CITY OF ALBUQUERQUE
PLANNING DEPARTMENT
DEVELOPMENT REVIEW BOARD

Project# 1003272

14DRB-70065 MAJOR - 2YR SUBD IMP AGMT EXT (2YR SIA)

RIO GRANDE ENGINEERING agent(s) for TITAN INVESTMENTS LLC request(s) the above action(s) for Lot(s) 4-A-1-A, **ALBUQUERQUE WEST Unit(s) 2**, zoned SU-1 PDA W/C3 USES, located on HIGH ASSESTS WAY BETWEEN TAYLOR RANCH RD AND ALL SAINTS RD containing approximately 1.54 acre(s). (C-13)I

- KEYED NOTE:
- ① 8' INTEGRALLY COLORED, AND TEXTURED CONC. PEDESTRIAN CROSSWALK RE: DETAIL 7/A1.1
 - ② LIGHT POLE LOCATION RE: DETAIL 3/A1.1
 - ③ PROPOSED 6' CONC. SIDEWALK RE: CIVIL FOR INFO

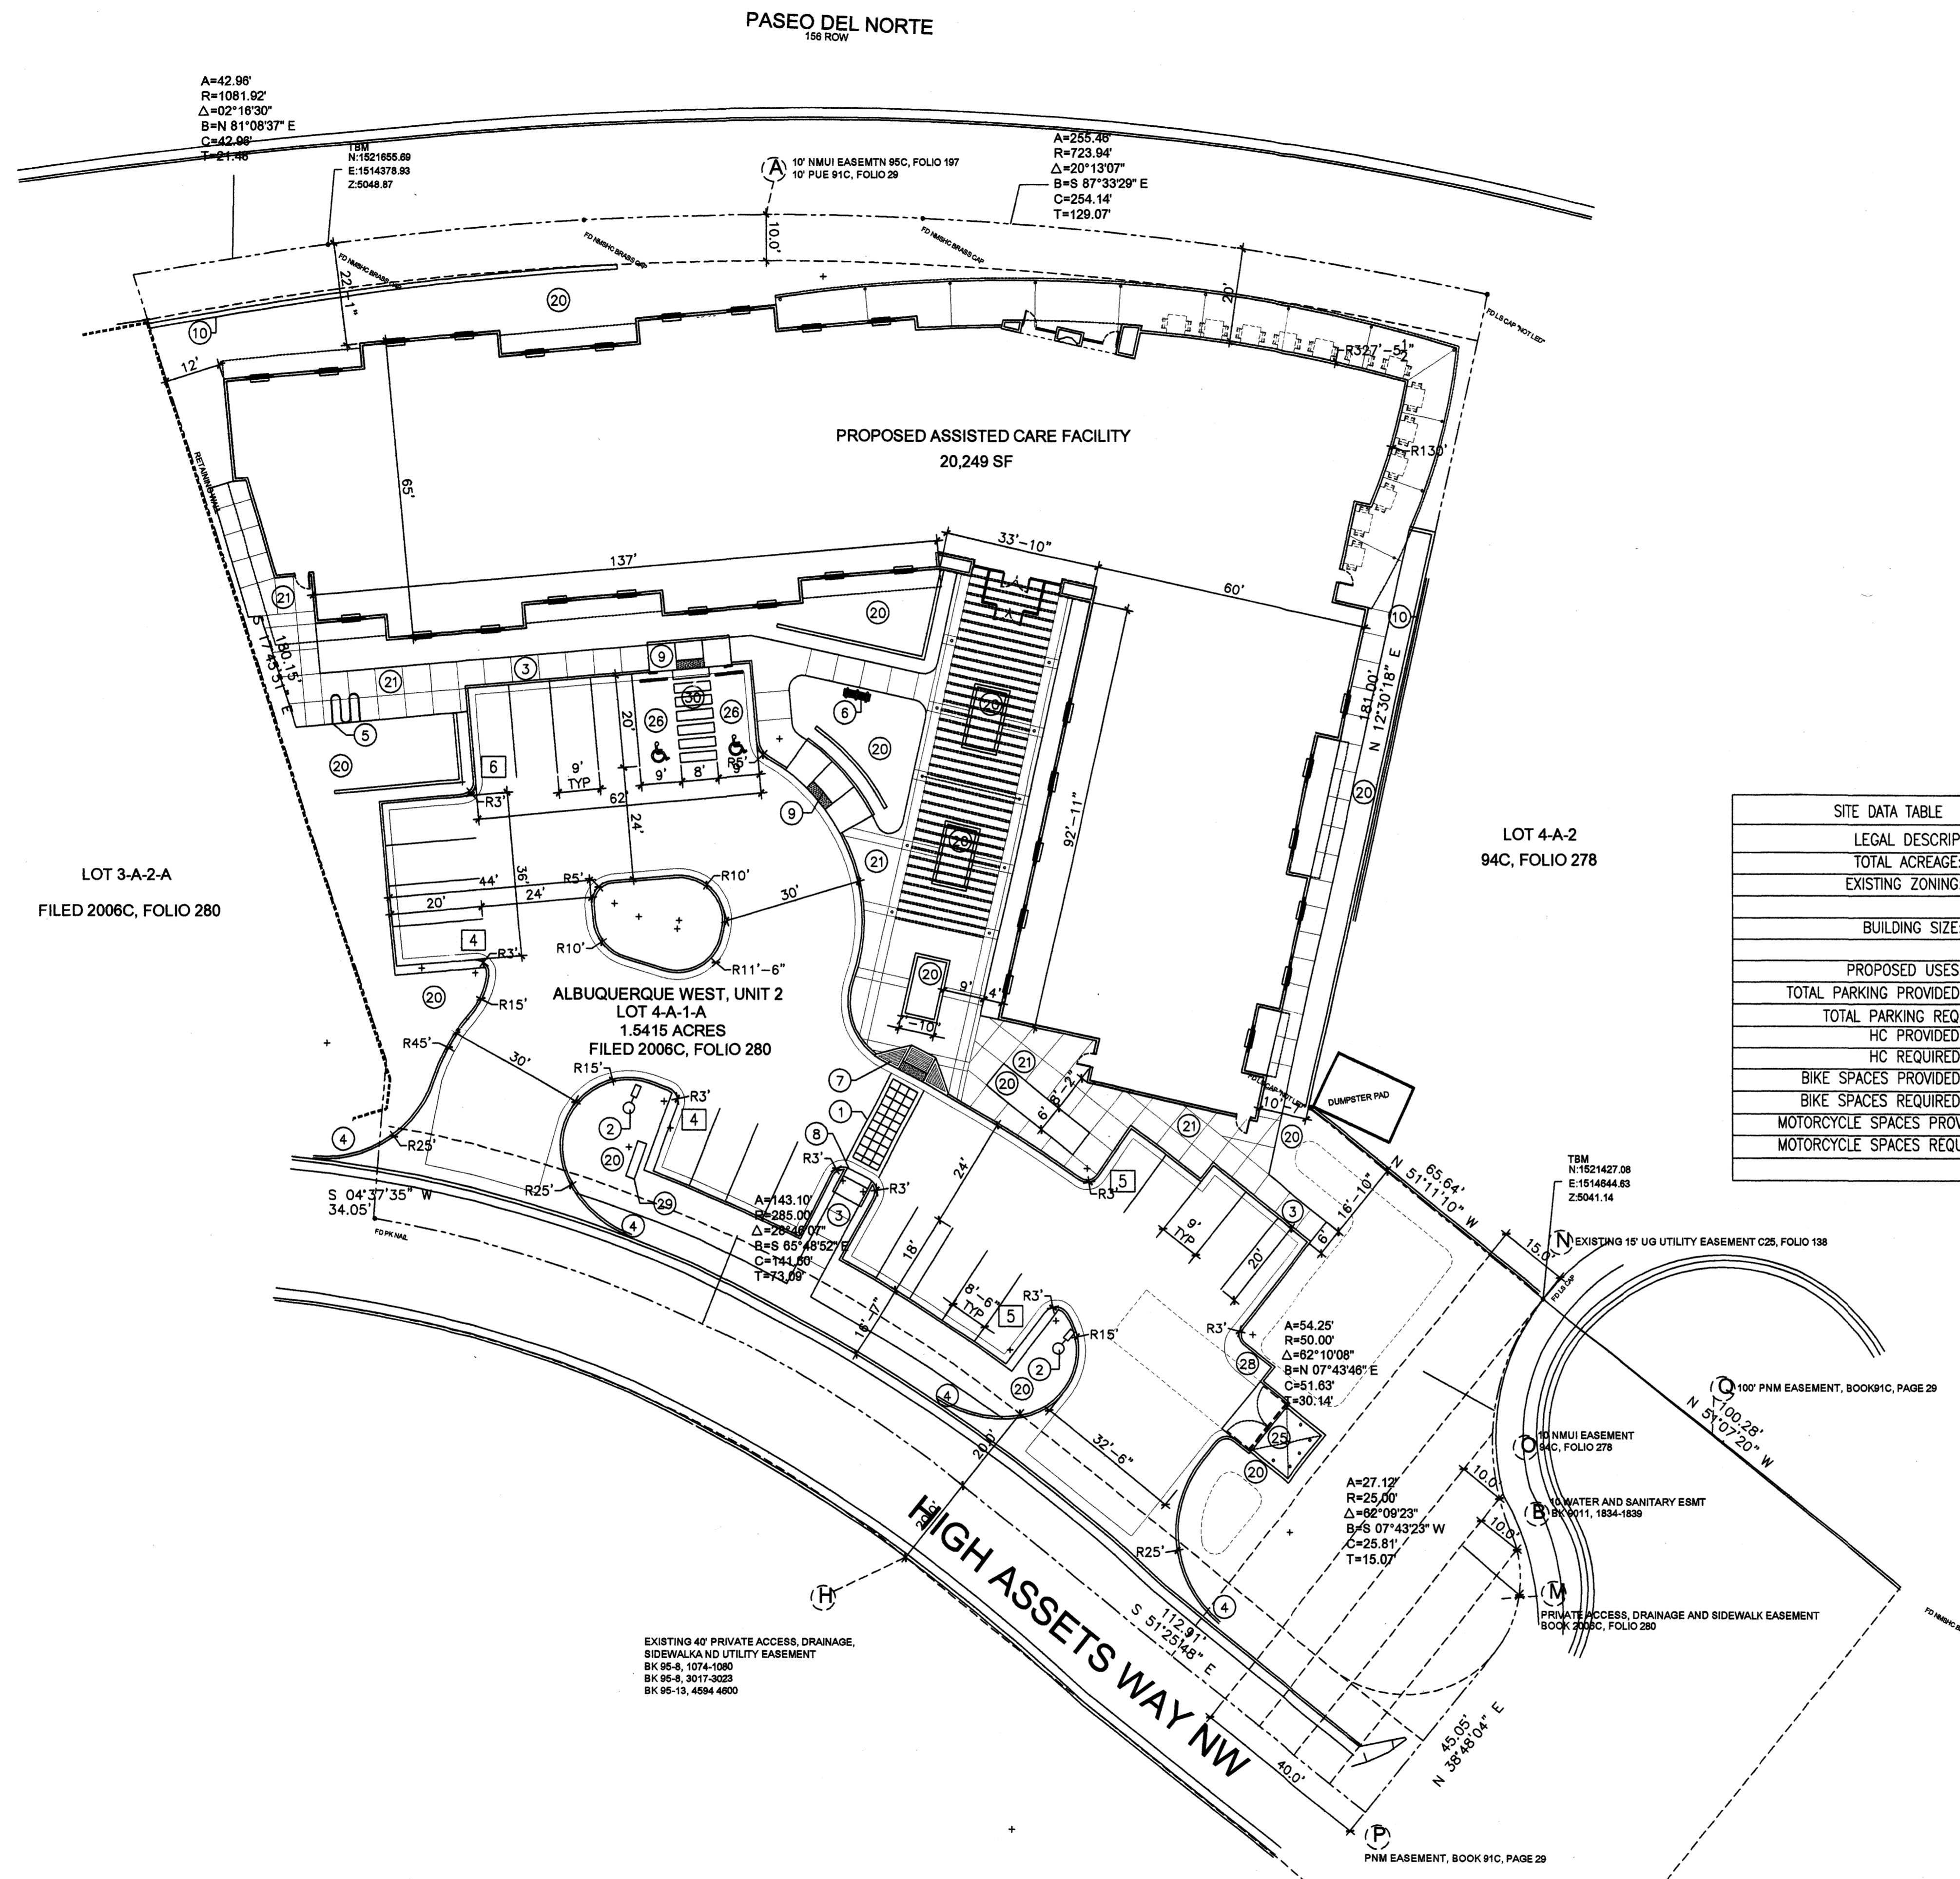
The most recent aerial information (2010) indicates that the All Saints is missing curb and gutter as well as sidewalk. This will require an infrastructure list.

Please clarify existing versus proposed conditions.

The proposed sidewalk must be built at the property line, not at back of curb.

Sidewalk is required along entire frontage.

Local roadways (including private roadways) must have a 4-foot sidewalk with a 6-foot setback from back of curb.

The sidewalk on the adjacent lot is offset from the curb. Please revise the plan accordingly.

Define all line types.

Provide an exhibit showing the location of sidewalk and defining the distance from face of curb to the property line. Right of way dedication maybe required.

Keyed notes H & M define private access easements; clarify the location of these easements and provide recording information.

Is All Saints Road missing curb and gutter? Clarify.

Label the compact parking spaces by placing the words “compact” on the pavement of each space.

For passenger vehicles, the minimum end island radius is 15 feet.

PROPOSED ASSISTED CARE FACILITY  
20,249 SF  
ALBUQUERQUE WEST, UNIT 2  
LOT 4-A-1-A  
1.5415 ACRES  
FILED 2006C, FOLIO 280

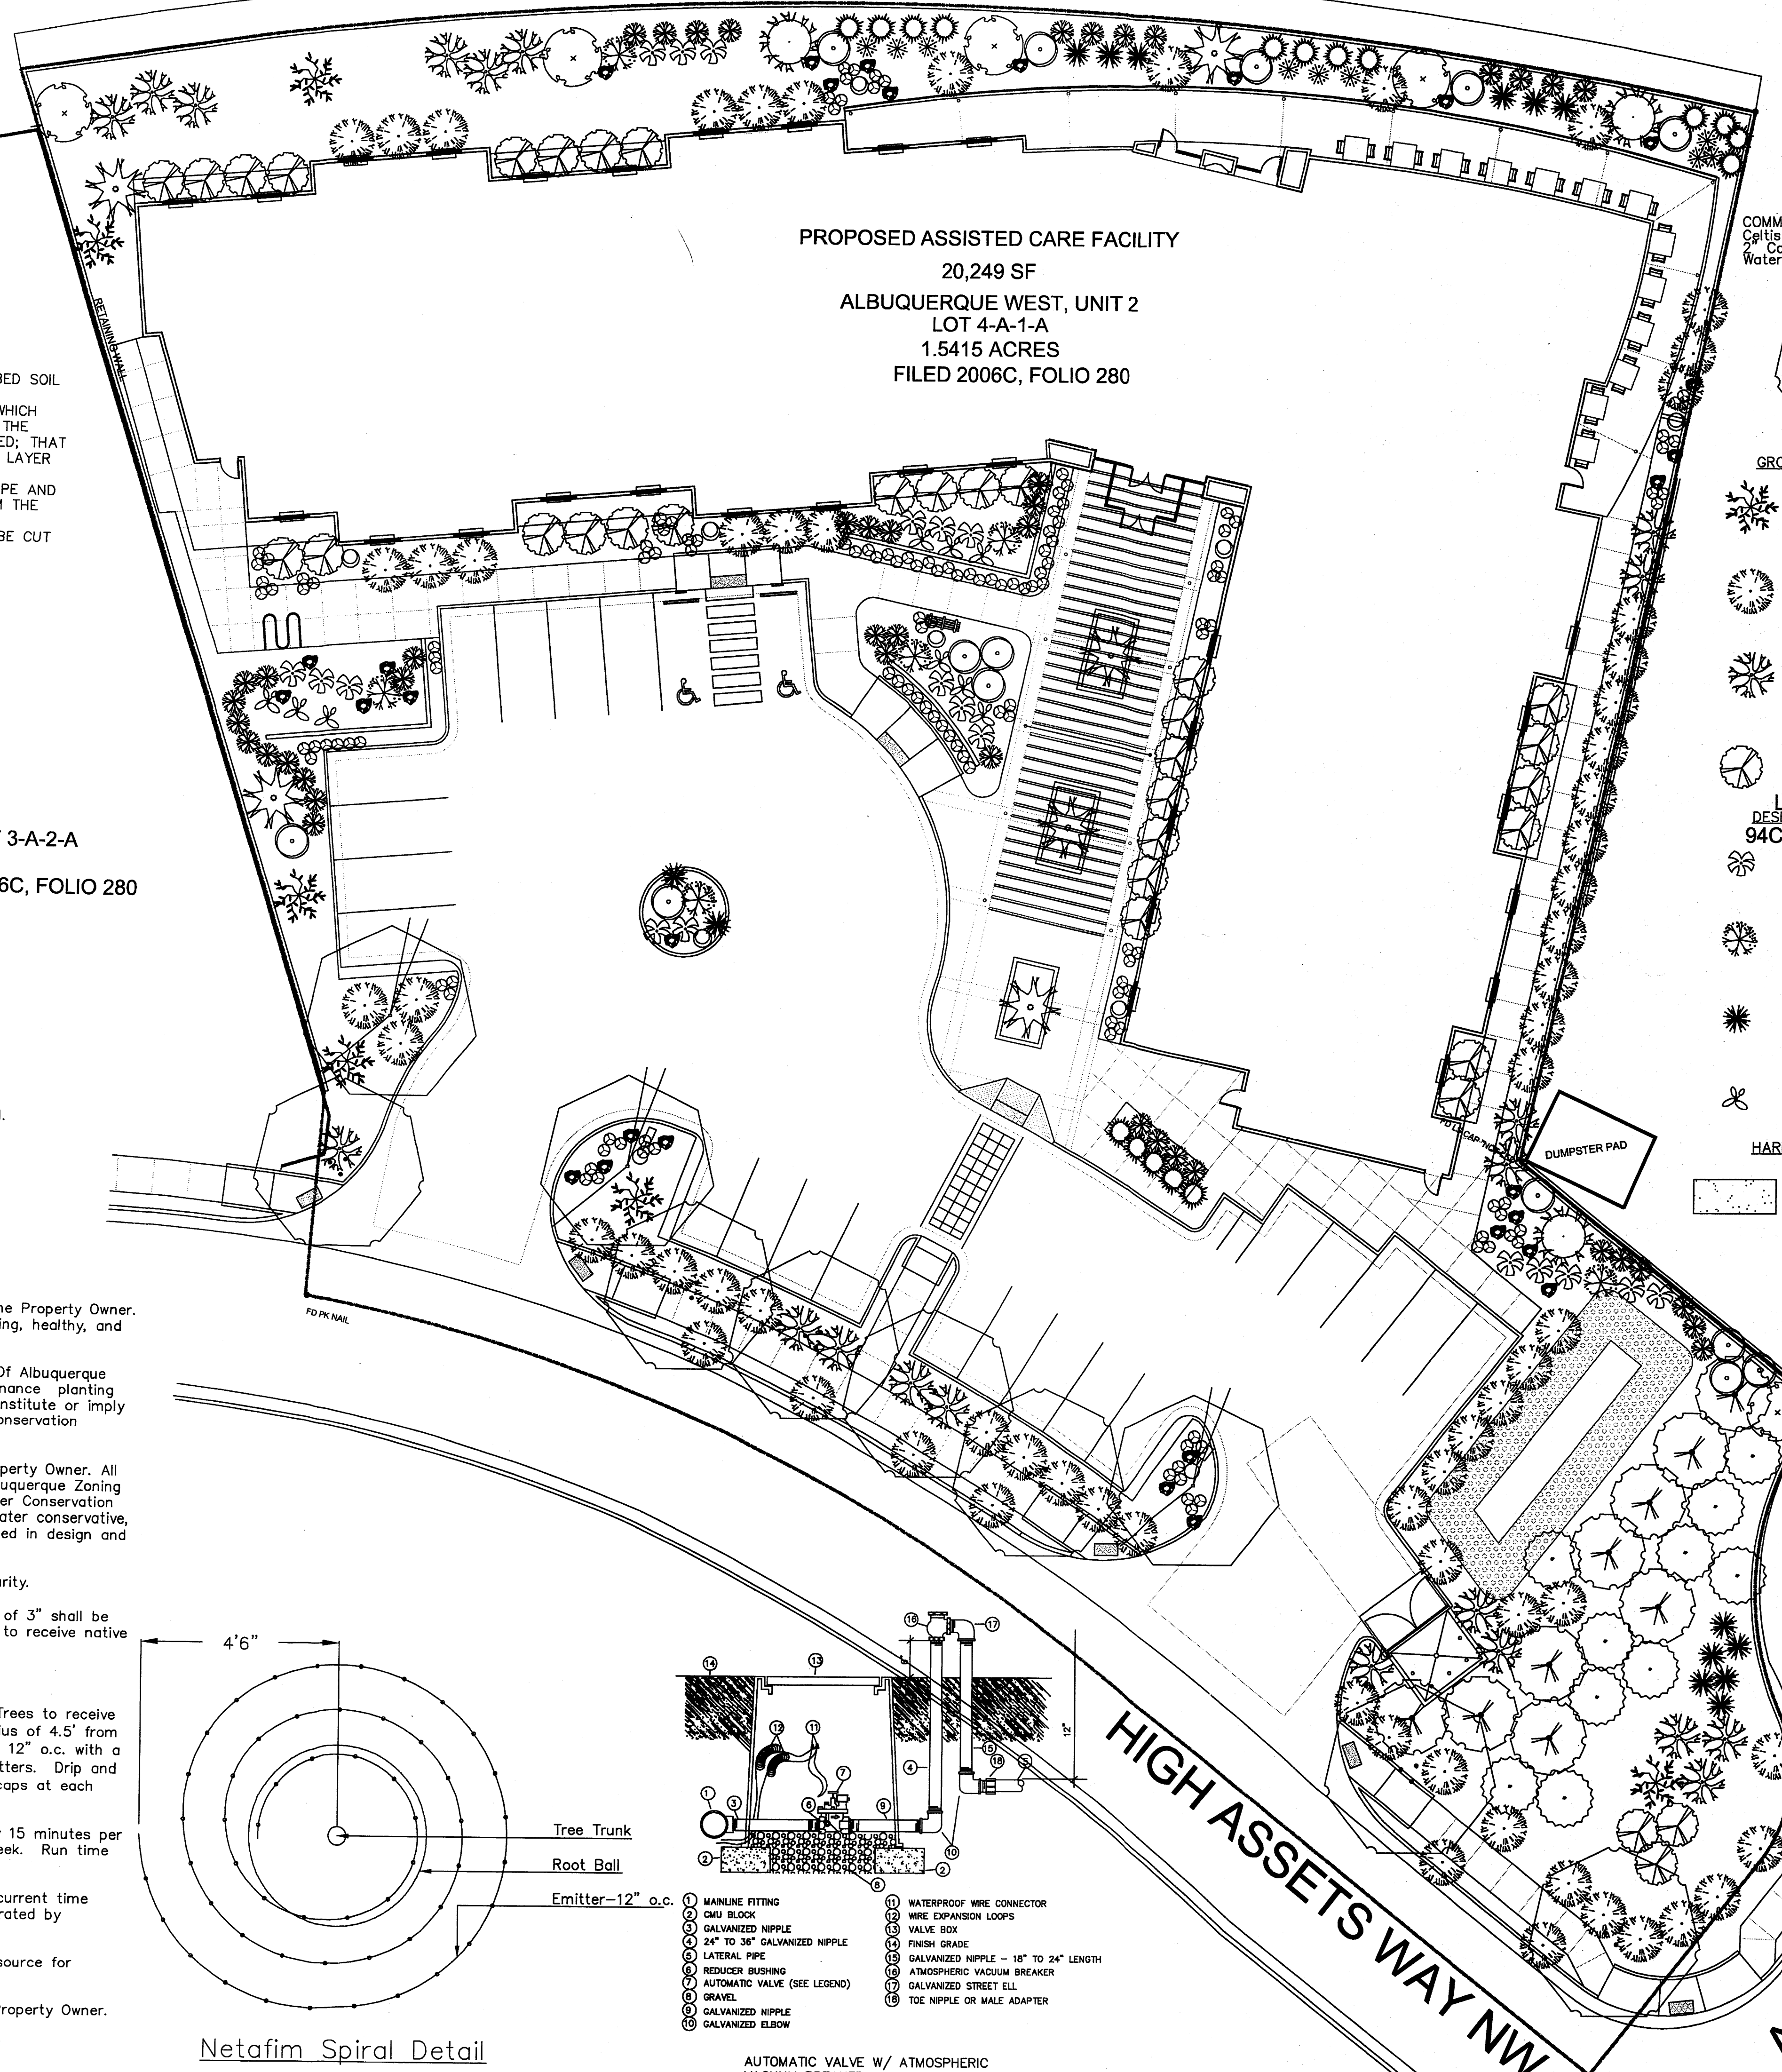
Hydrology has an approved Grading and Drainage Plan stamp date 11-22-11. It should be in the Site Plan for Building Permit.

It appears the street does not have curb and gutter at the south east corner of the site. Since the curb and gutter is new, the project is setting grade and the Improvements are to be built per Work Order.
